RE: **CAO23-030** Review Letter 1; 5300 Butterworth Rd, Mercer Island, WA 98040

The City of Mercer Island Community Planning and Development Department has completed a review for compliance with the zoning code, Title 19 of the Mercer Island City Code (MICC) for the above Critical Area Review 2 application. The following issues need to be addressed in your resubmission:

DISTURBED AREA
LANDSCAPE PLAN

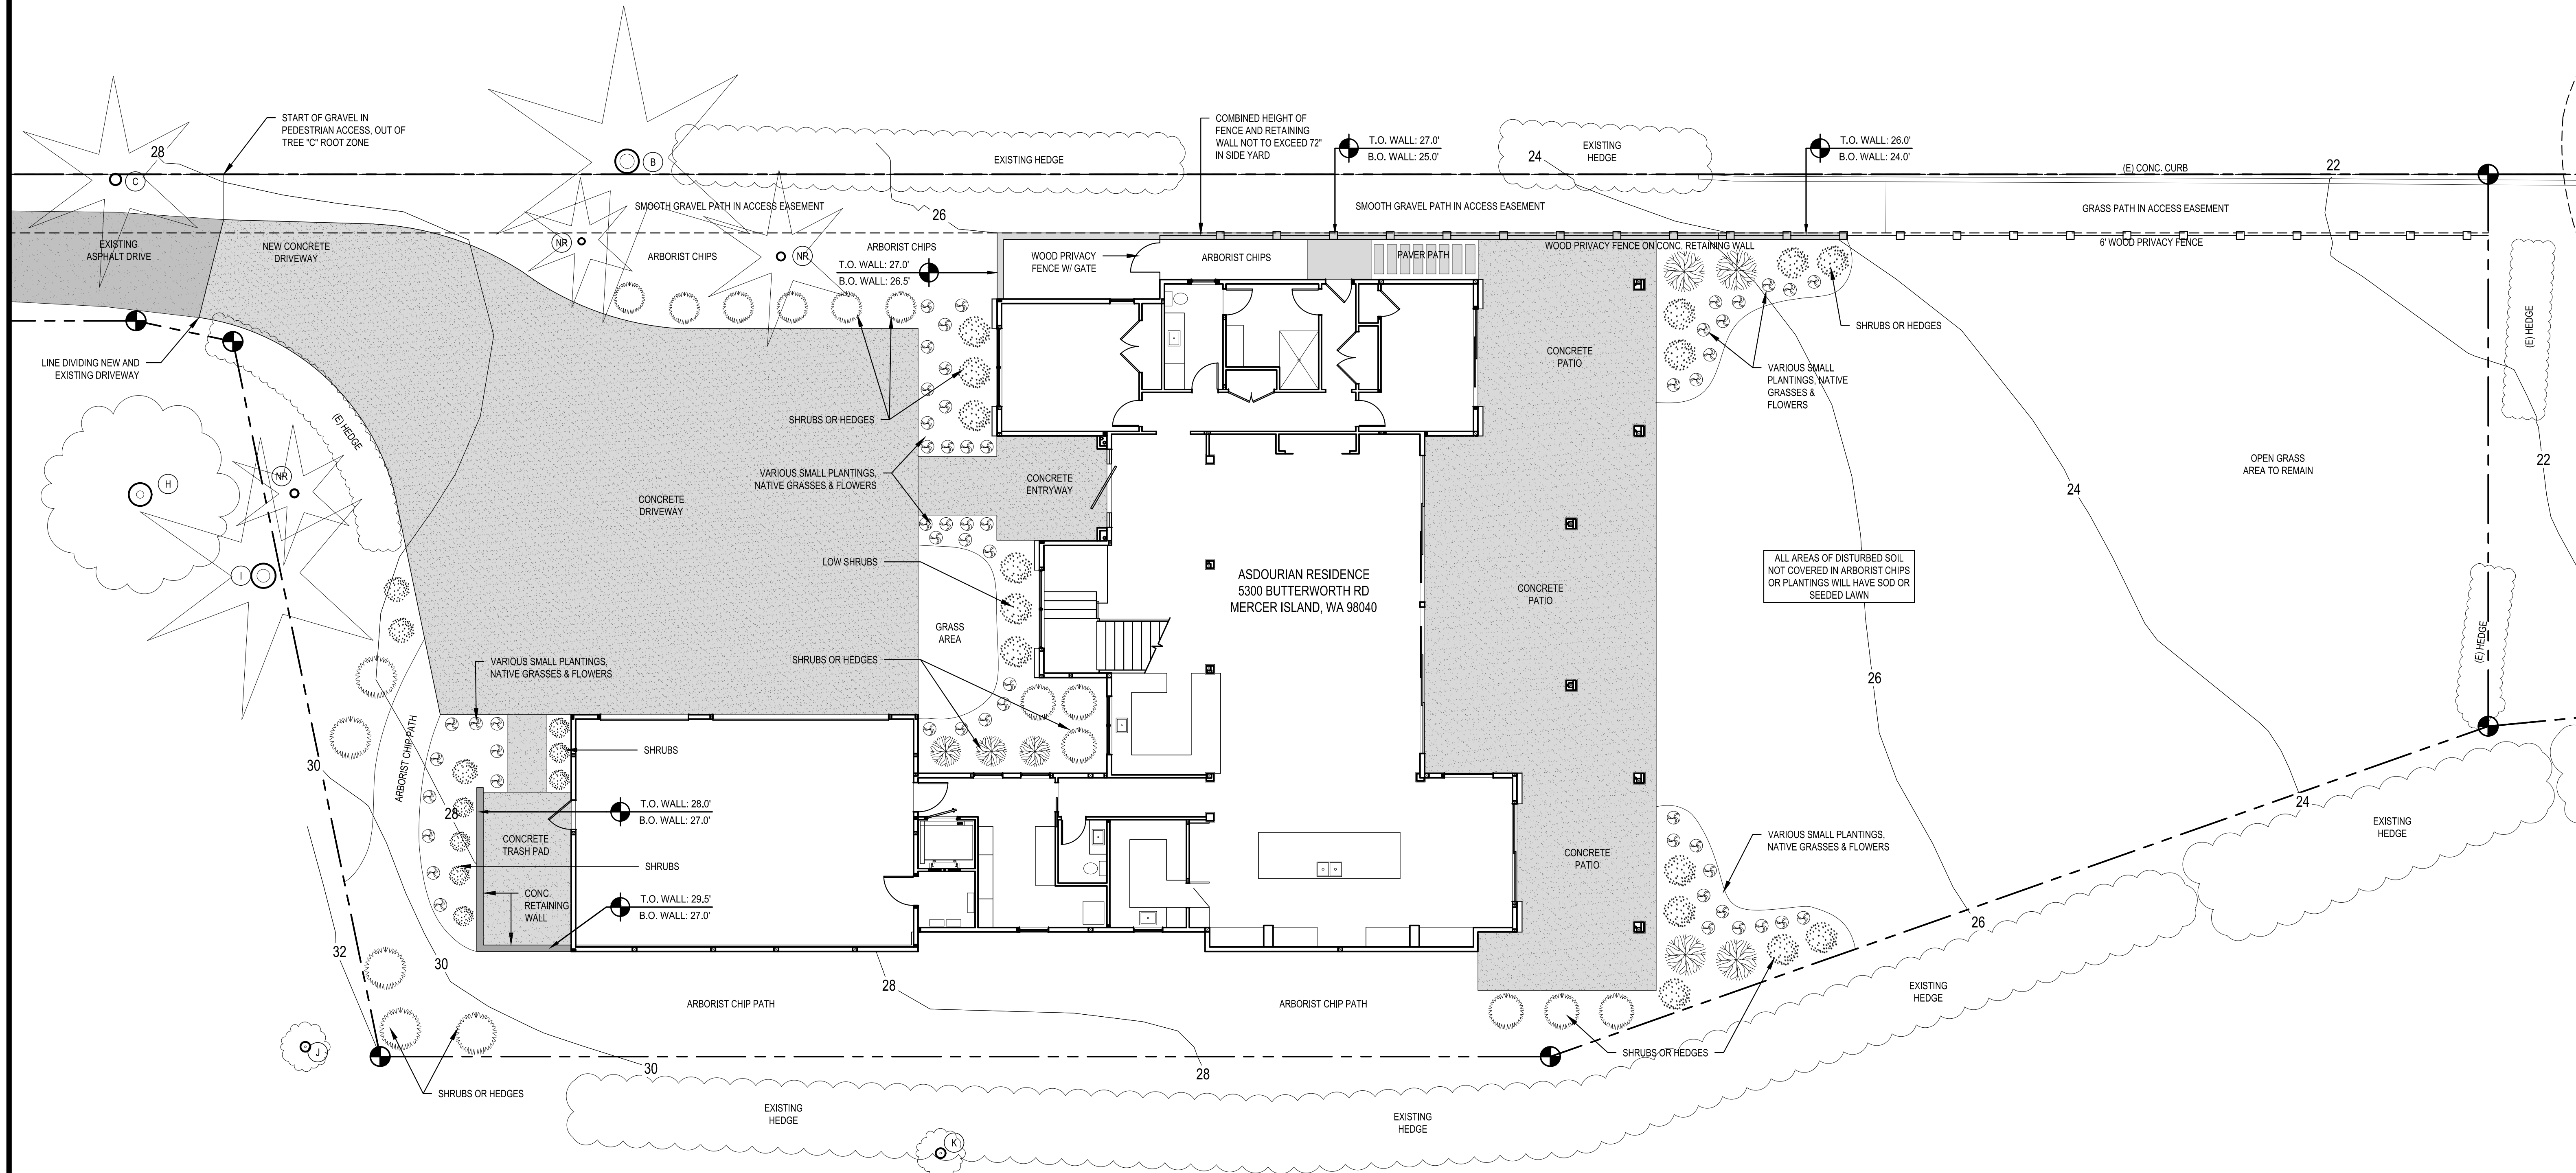
4. The Critical Area Study should include Mitigation Sequencing consistent with MICC 19.07.100 for the alteration to the geologically hazardous areas. Provide an updated geotechnical report that specifically contains mitigation sequencing for the proposed development.
5. The statement of risk provided by Geotech Consultants, Inc on Page 5 of the Geotechnical Engineering Study and Critical Areas Study does not exactly match one of the statements of risk found in MICC 19.07.106(B)(3). Provide an updated geotechnical report that makes a statement of risk matching one of these statements.
6. Provide a landscaping plan that includes the landscaping of all disturbed areas outside of building footprints and installation of hardscape that will be completed prior to final inspection per MICC 19.07.160(B)(2)(d).
